REVISION RESPONSE LETTER

**RE: Master Blaster
Site Development Plan
File Number PPR-17-056**

DATE: February 22, 2018

1 SITE PLAN  
SCALE: 1"=20'-0"

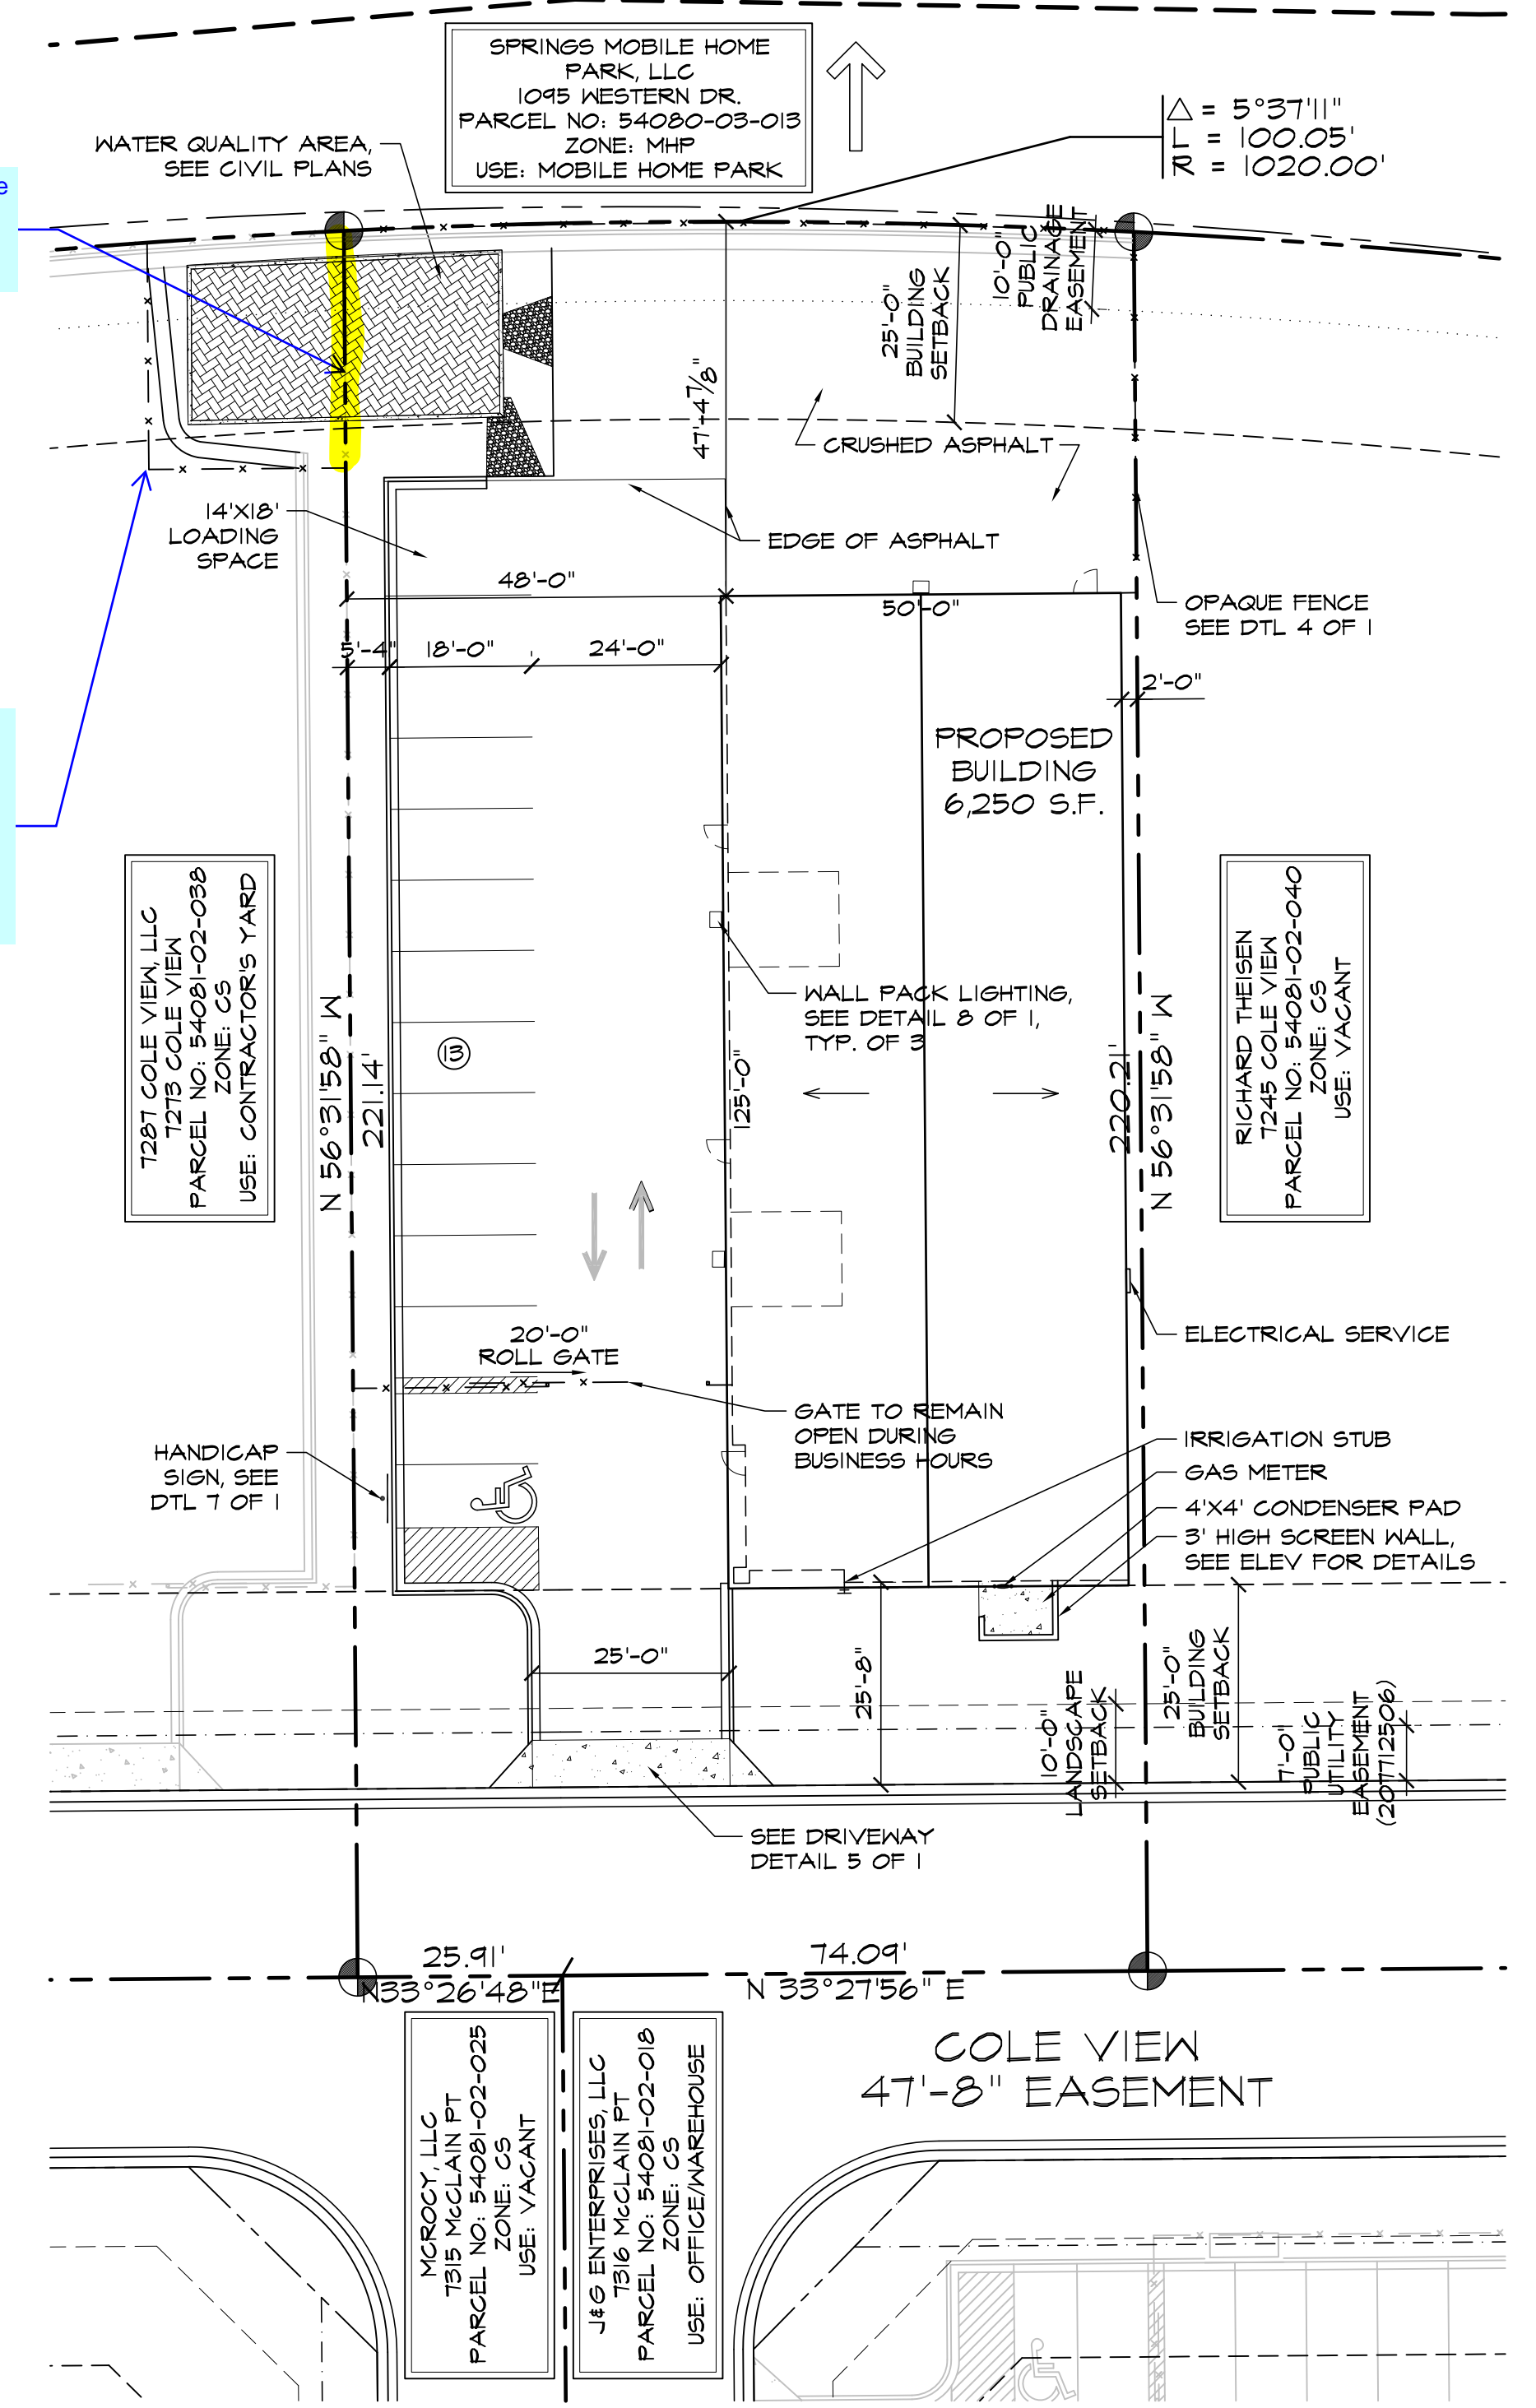
1. Should a sign be desired in the future, a separate sign permit must be obtained. **Noted**
2. A driveway permit is required prior to building permit authorization. **Noted**
3. Should the request be approved, all landscaping must be installed prior to CO. **Noted**
4. Should the request be approved, collateral for the proposed improvements is required prior to construction or the Pre-construction meeting. **Noted**
5. Please add ESQ-17-037 as the file number. **Updated**
6. The proposed use is unclear. Please explain why Master Blaster needs a warehouse as part of their business. **LOI updated**
7. 3 trees are required internally and not 2. Please update. **Updated**
8. Additional comments will be provided by PCD Engineering upon completion of the review.

Site Development Redlines

Plans have been updated per comments made on the plans.
